NORTH LEVEL DISTRICT INTERNAL DRAINAGE BOARD

Planning Reference: H20-0467-26
Siting of static caravan to be used as annexe to main dwelling
Annasfield, Old Fendyke, Sutton St James, Spalding

Block plan (Proposed Caravan Annexe) Drawing 1

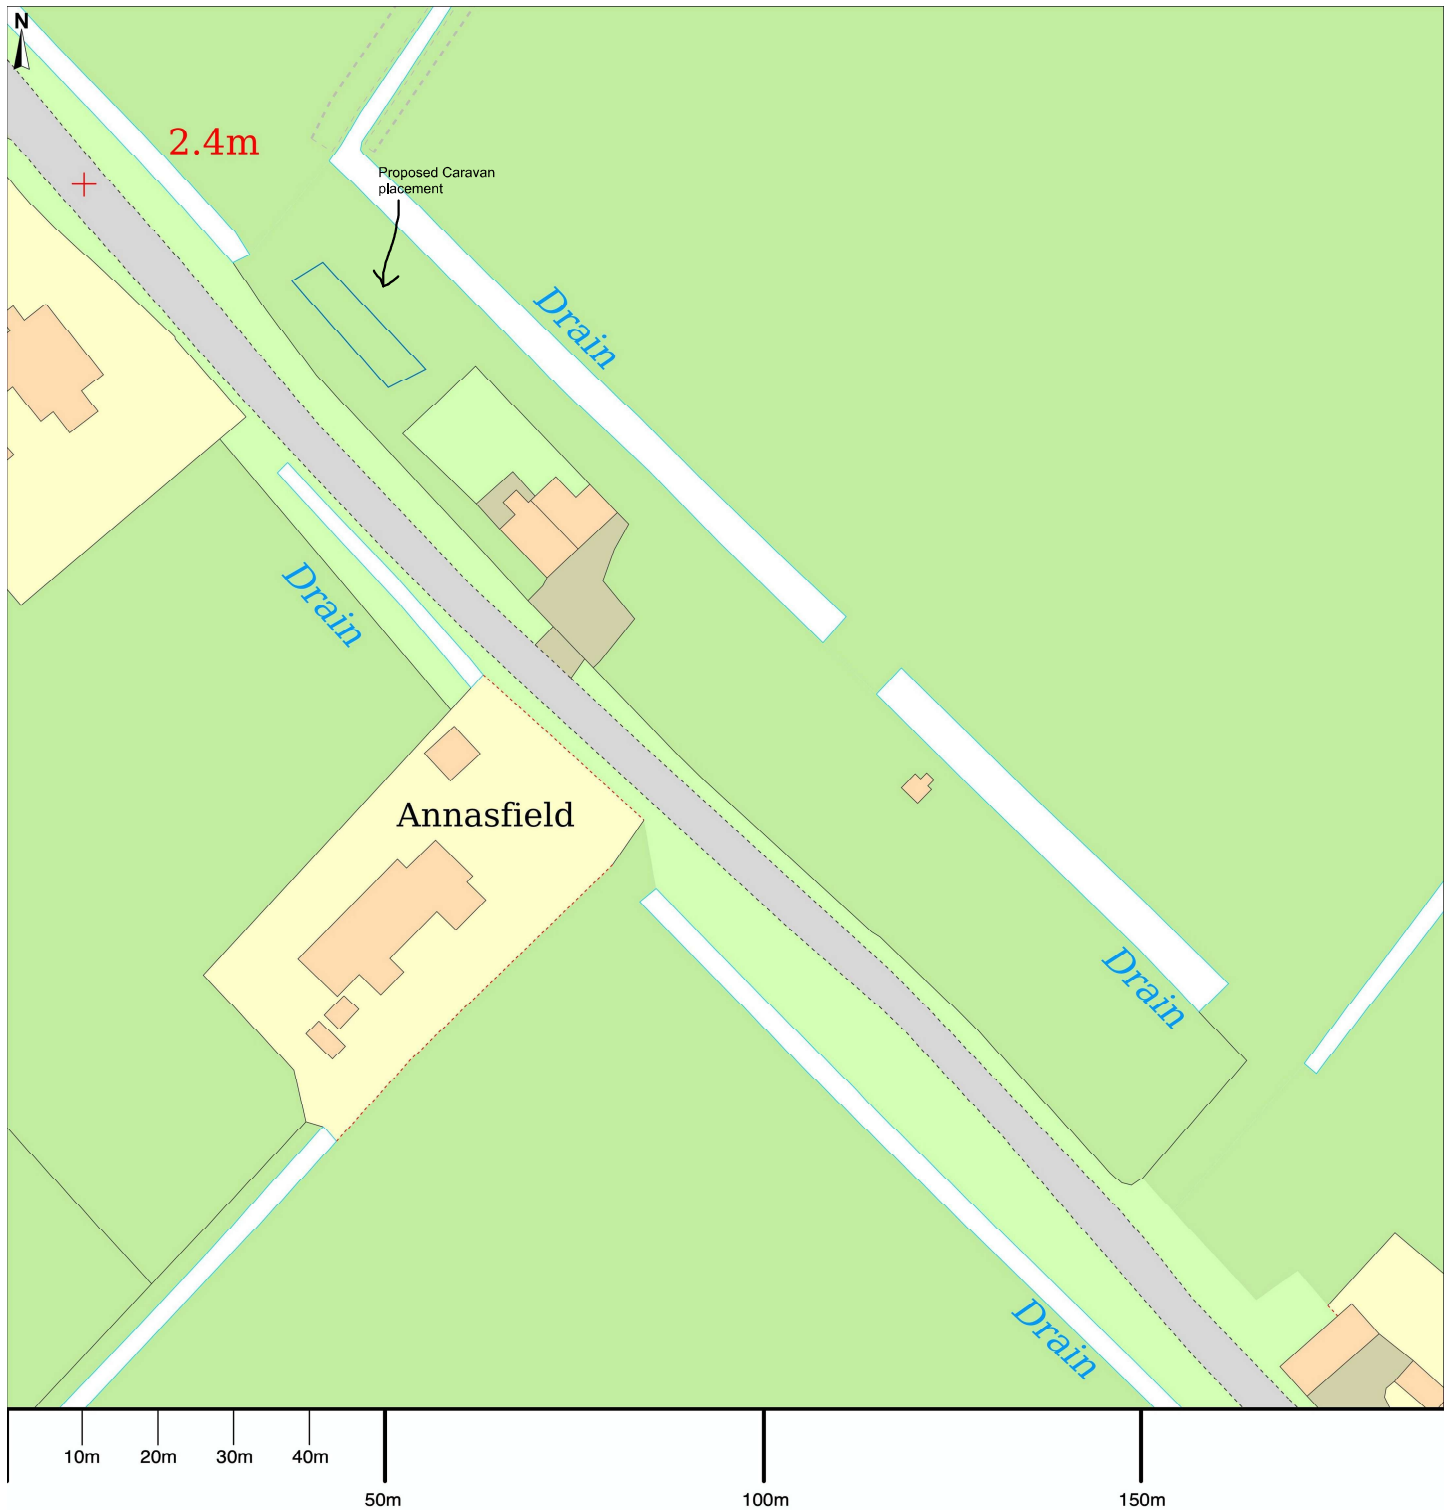
The Board's Nutwalk Farm Drain lies on the boundary of the site and therefore the Board's Byelaws apply.

In particular, Byelaw no. 10 which states that "no person without the previous consent of the Board shall erect any building or structure whether temporary or permanent within 9 metres of the drain".

Formal land drainage consent will be required to discharge any surface or treated water to the existing watercourse.
